Current Zoning: N1-A (neighborhood 1-A)
Proposed Zoning: N1-F(CD) (neighborhood 1-F, conditional)

Approximately 0.997 acres located along the west side of Park South Drive, east of Parkstone Drive, and north of Archdale Drive.

The petition proposes to develop two triplex buildings and one quadplex on two parcels currently developed with two single family detached homes.

**STAFF
RECOMMENDATION**

RZP-2023-134

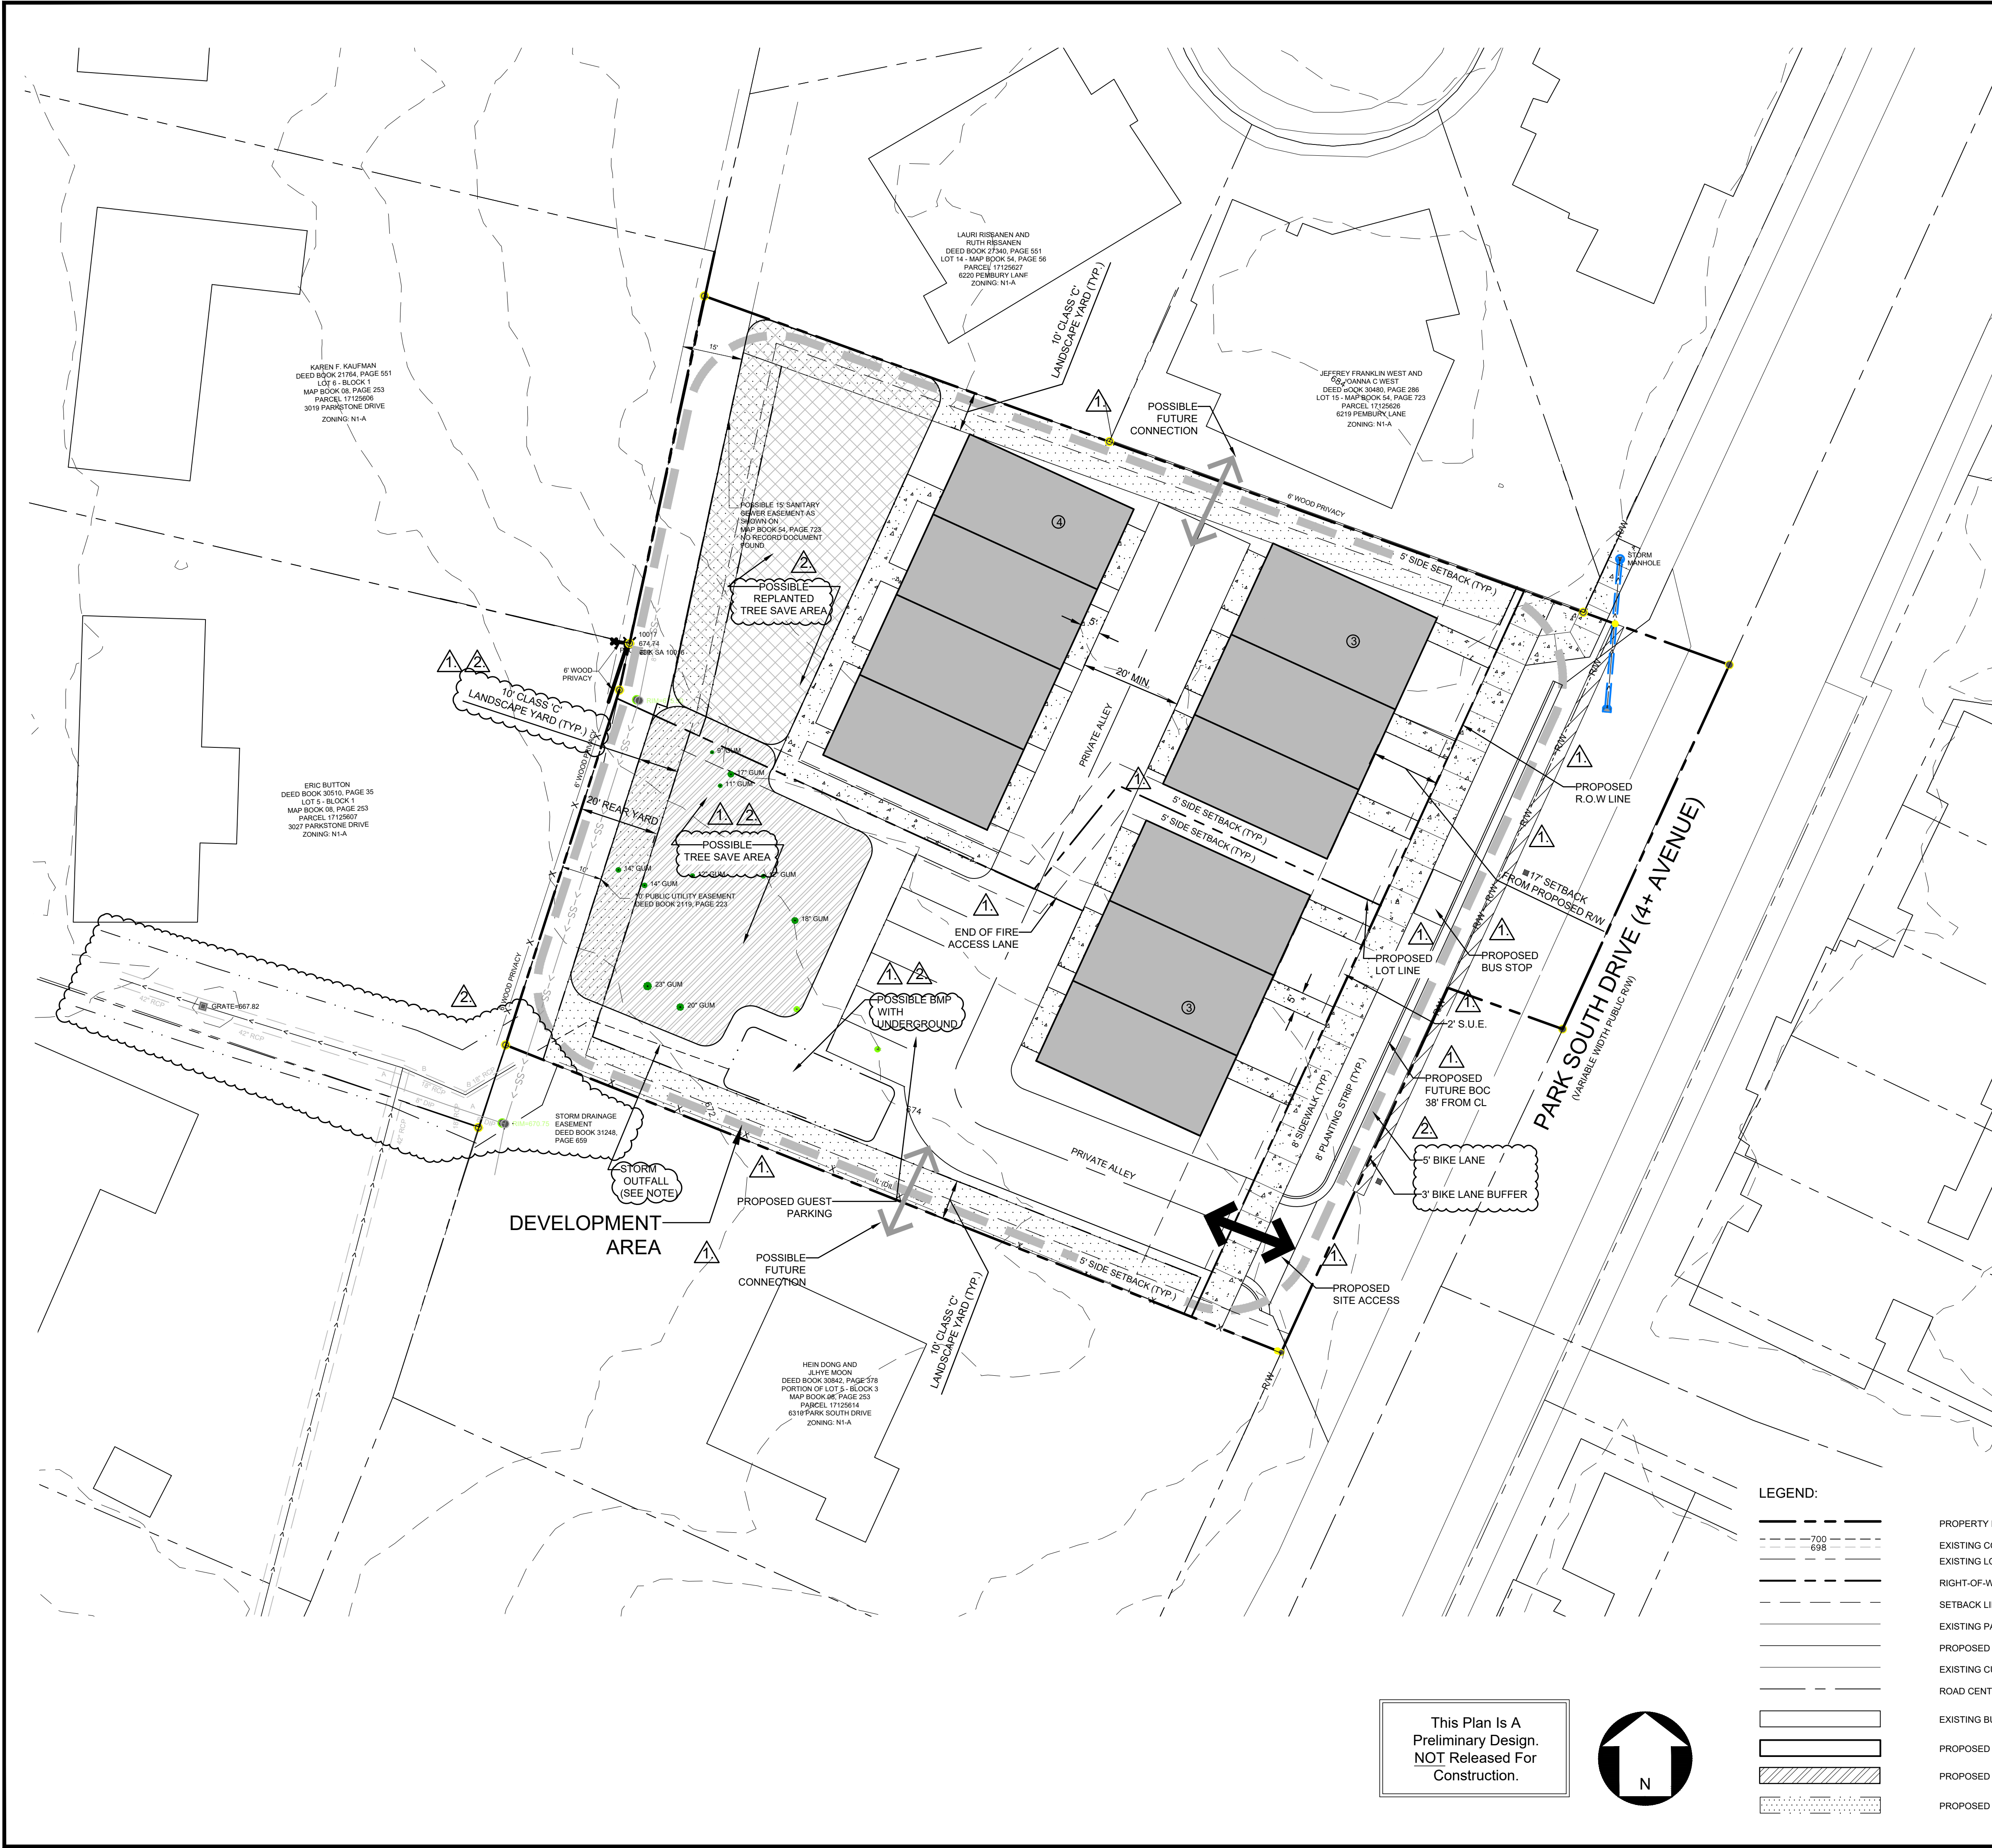
2. ~~Clarify if the tree save area shown on the site plan is outside of the demolition plan.~~ **Addressed**
3. **The replanted tree save area will have to be at a higher rate than the required minimum of 15% of the site. Increase the proposed tree save on the plan.**
